Our Ref: EP/37/20/HH
Your Ref:

Town & Country Planning Act 1990 (as amended)
Town & Country Planning (Development Management Procedure) (England) Order 2015
Application for Planning Permission for Works or Extension to a Dwelling

Development Single storey side/rear extension, part two storey rear extension rear extension, raising of roof height to create a second floor and front double garage.
Location 56 Angmering Lane Rustington

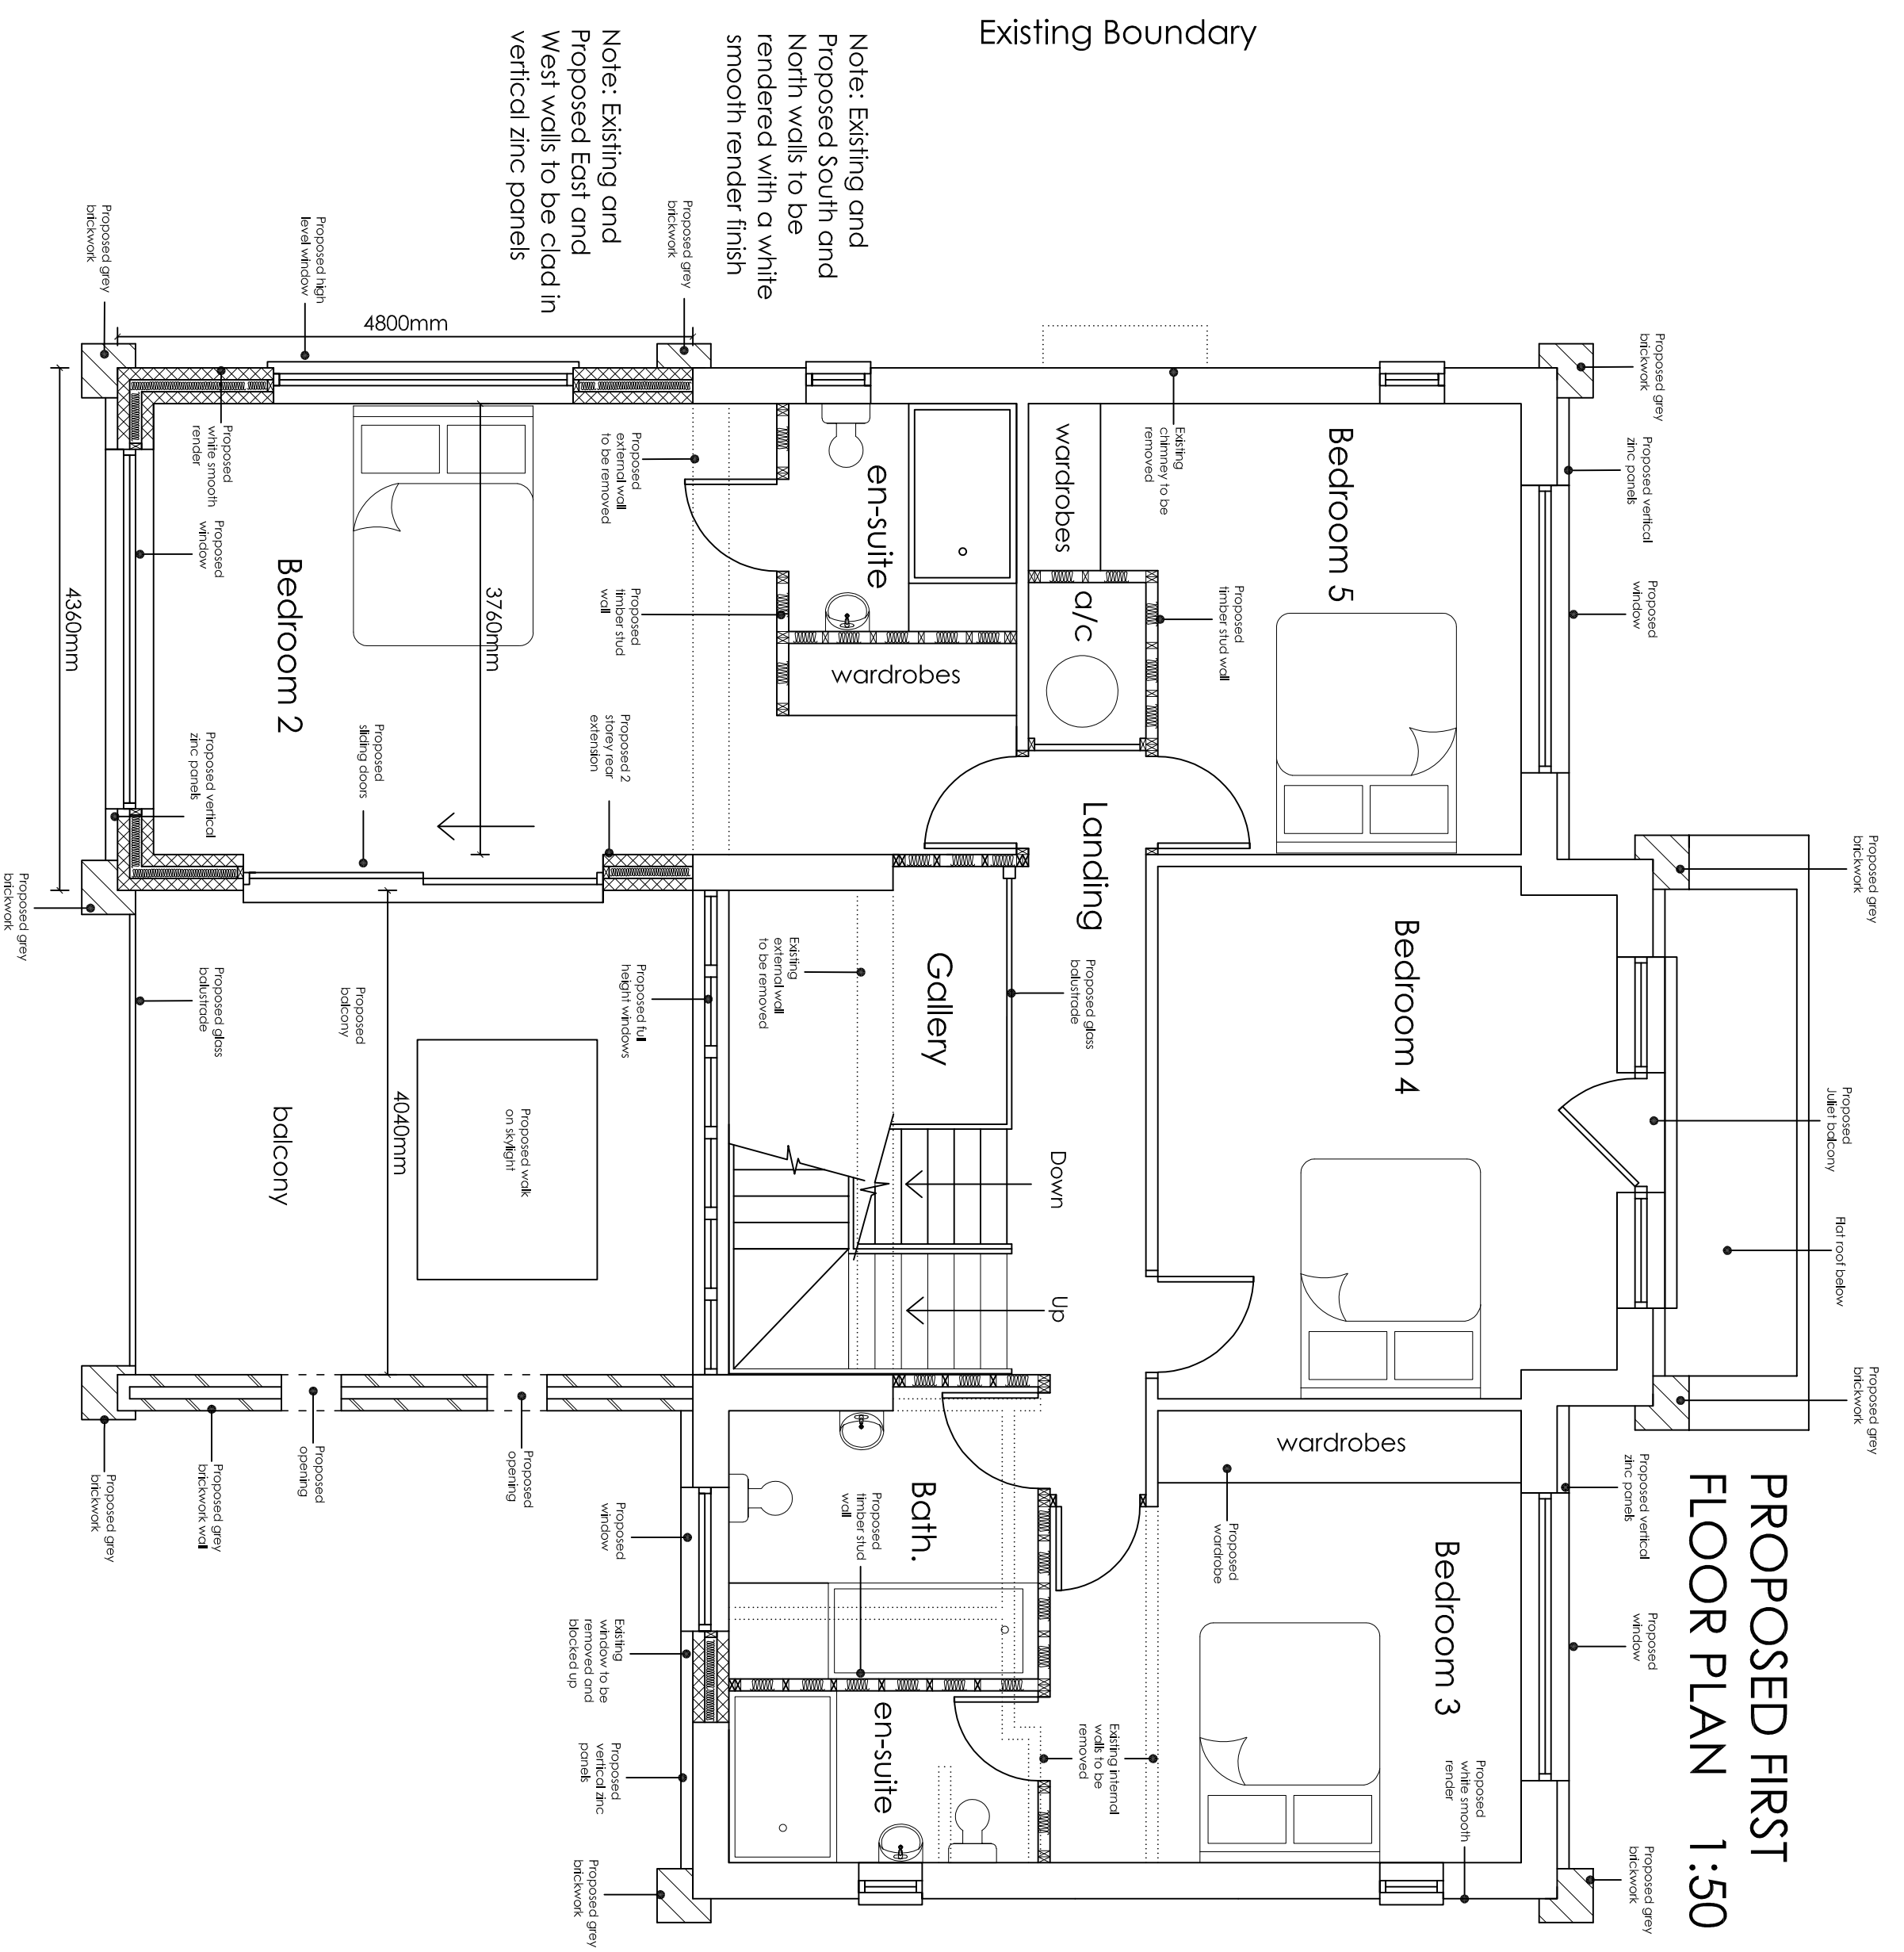
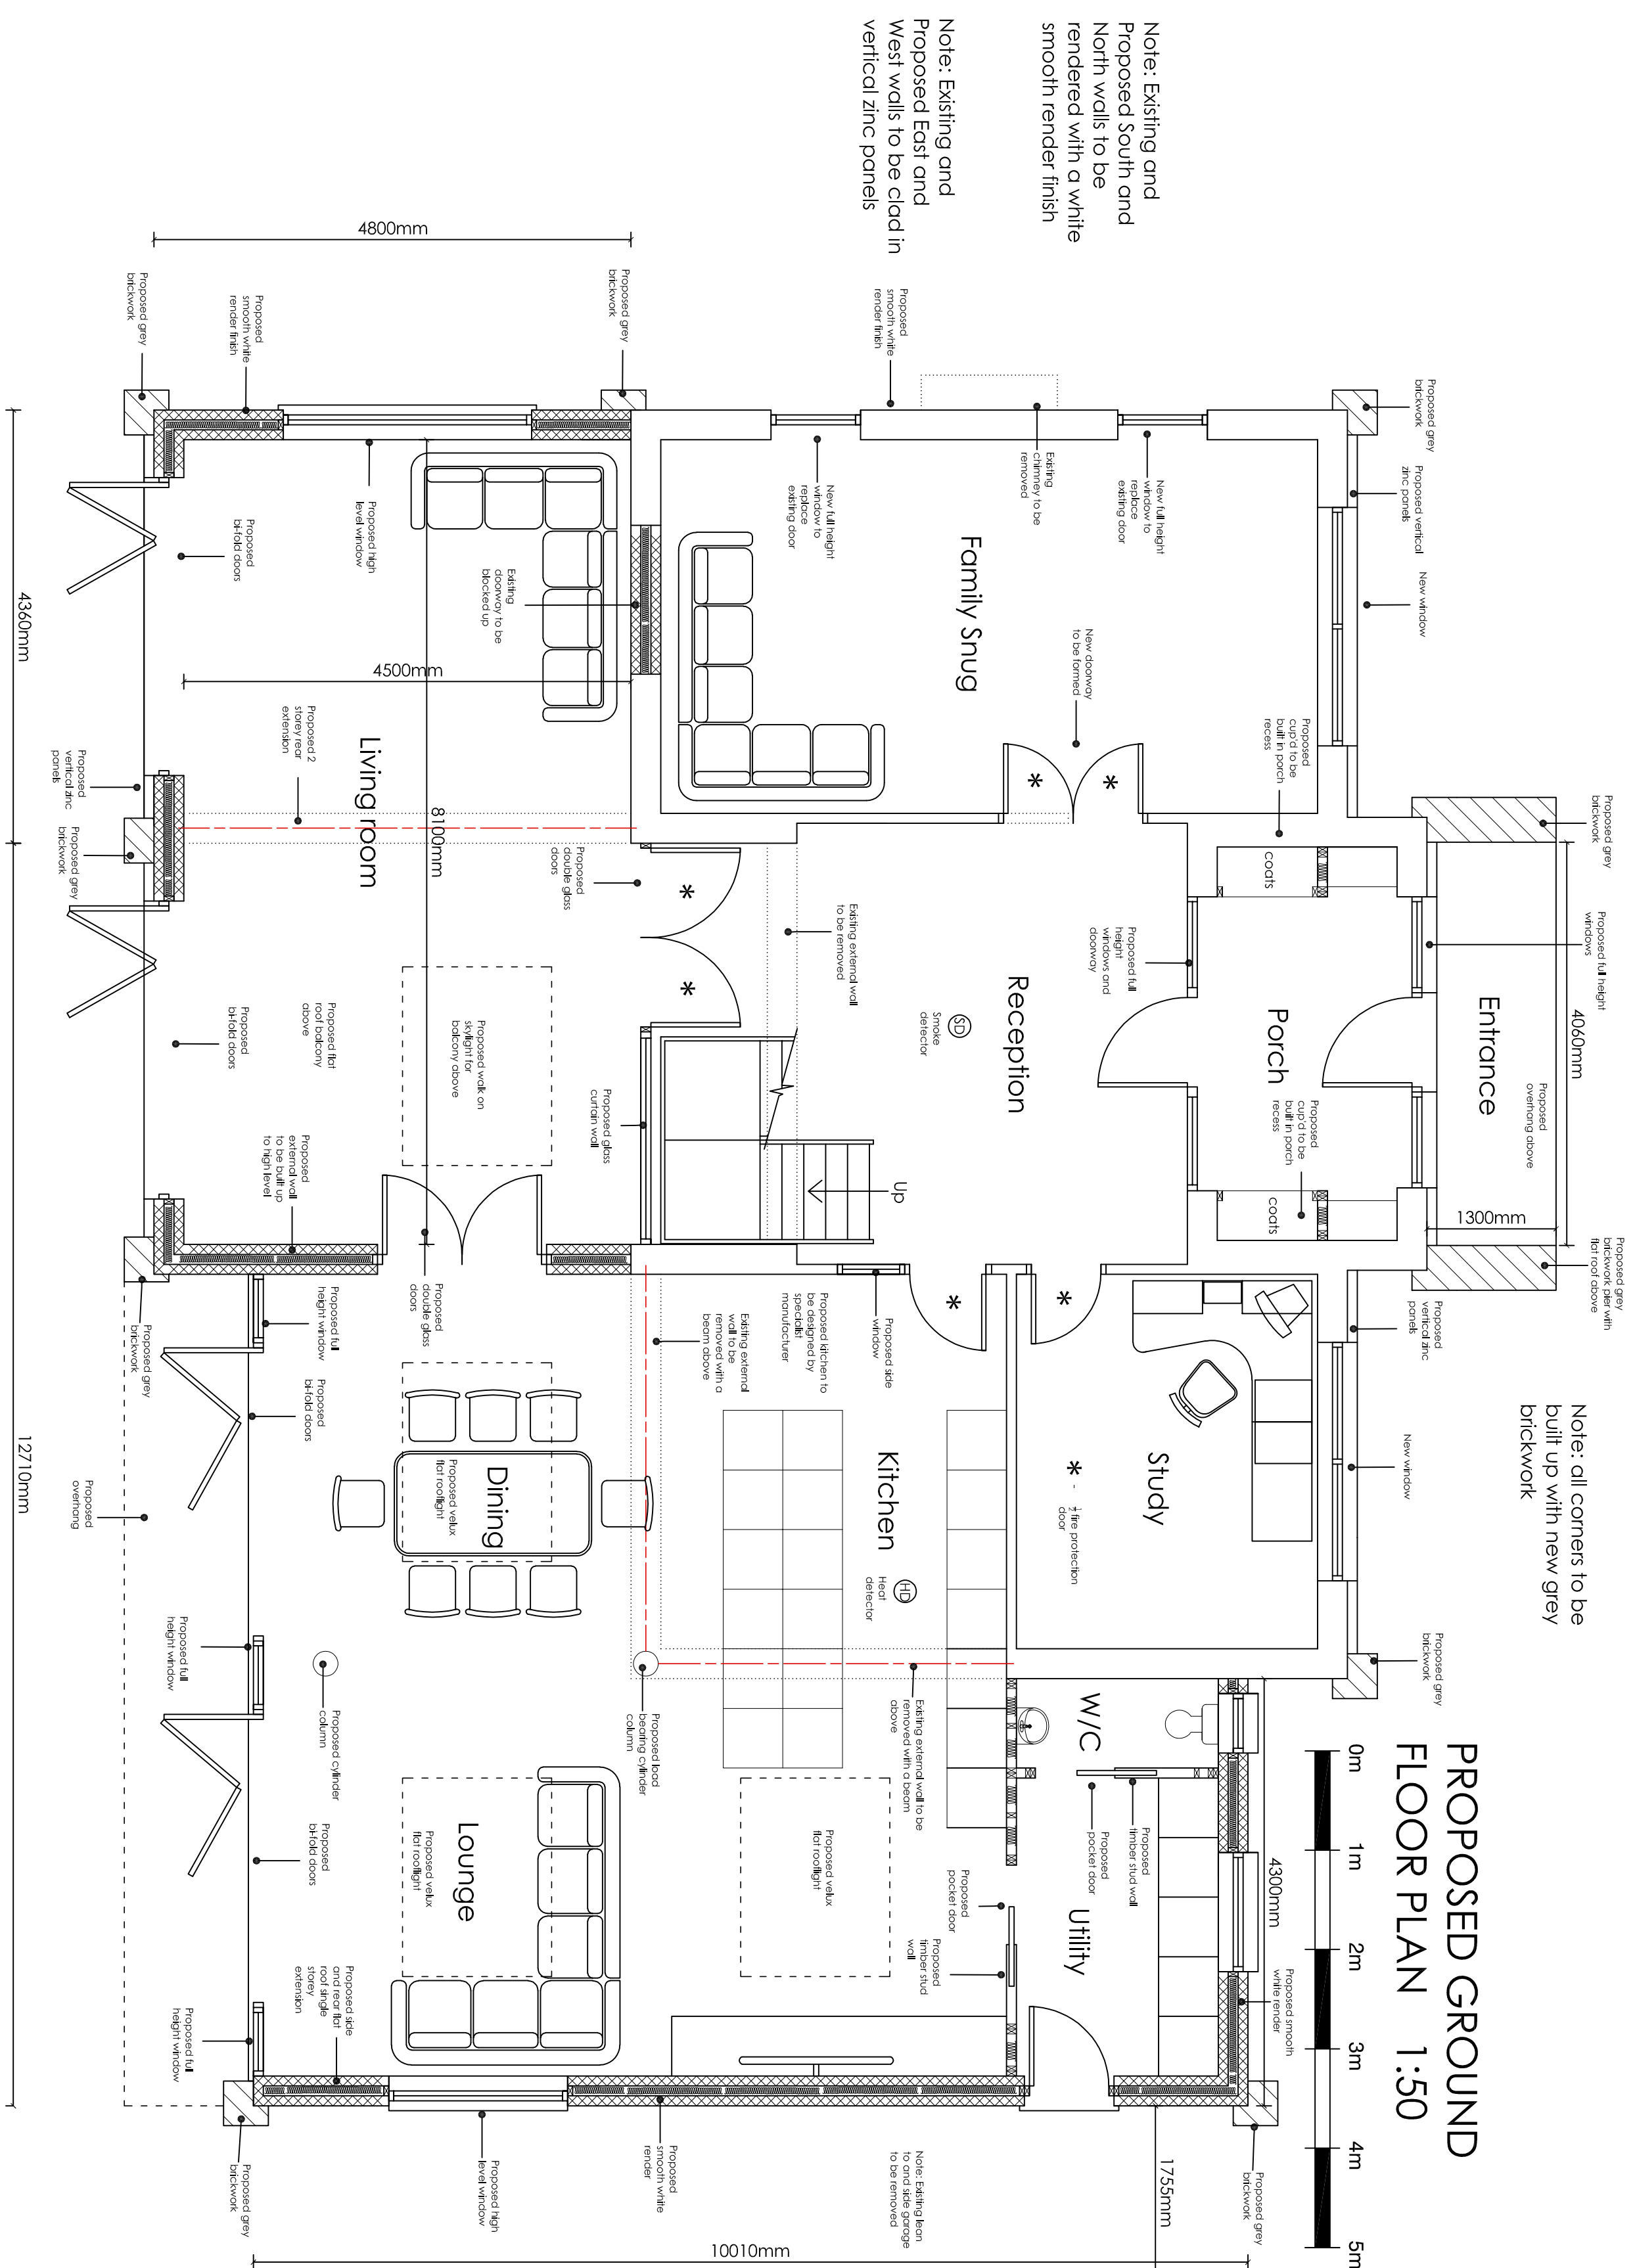
The width of the second floor does not match between the proposed floor plan and elevations.

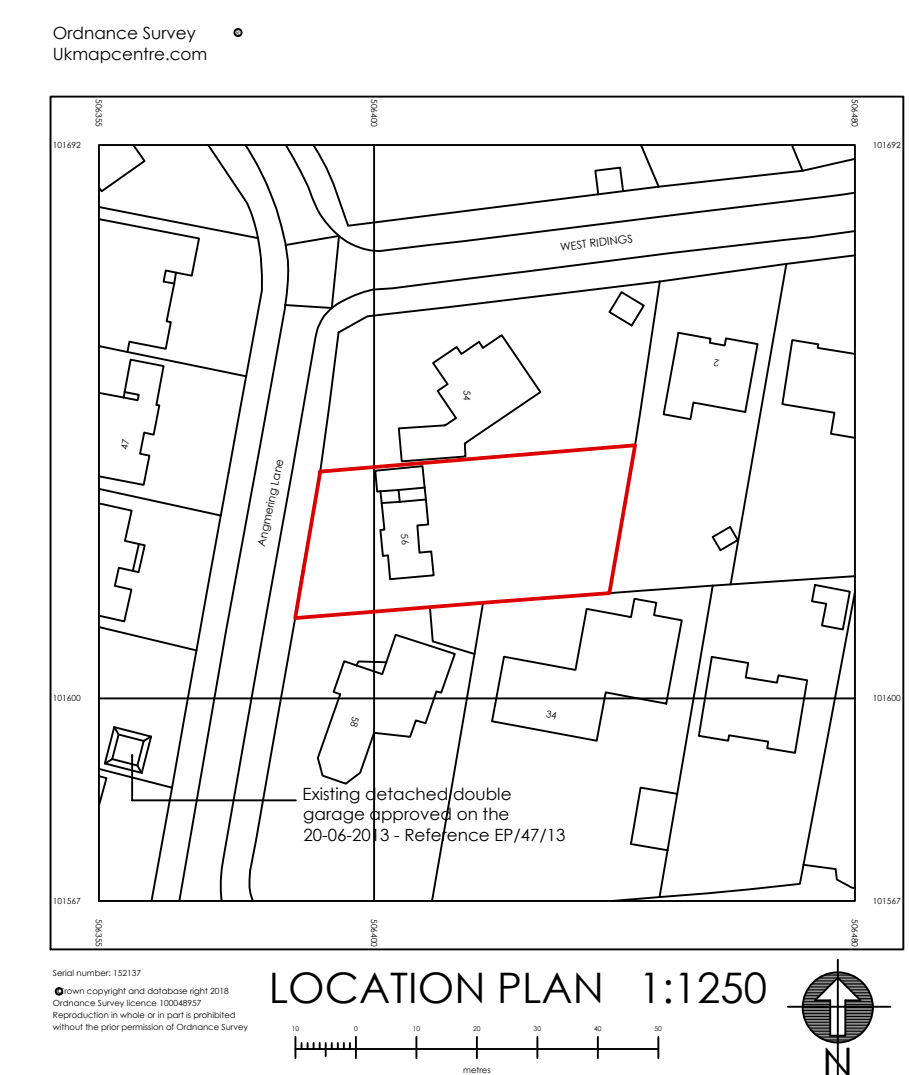
The size of the proposerty does not match between the proposed Block Plan and the proposed plans and elevations.

You are required to annotate the dimensions form each side of the proposed extensions to the site boundary.
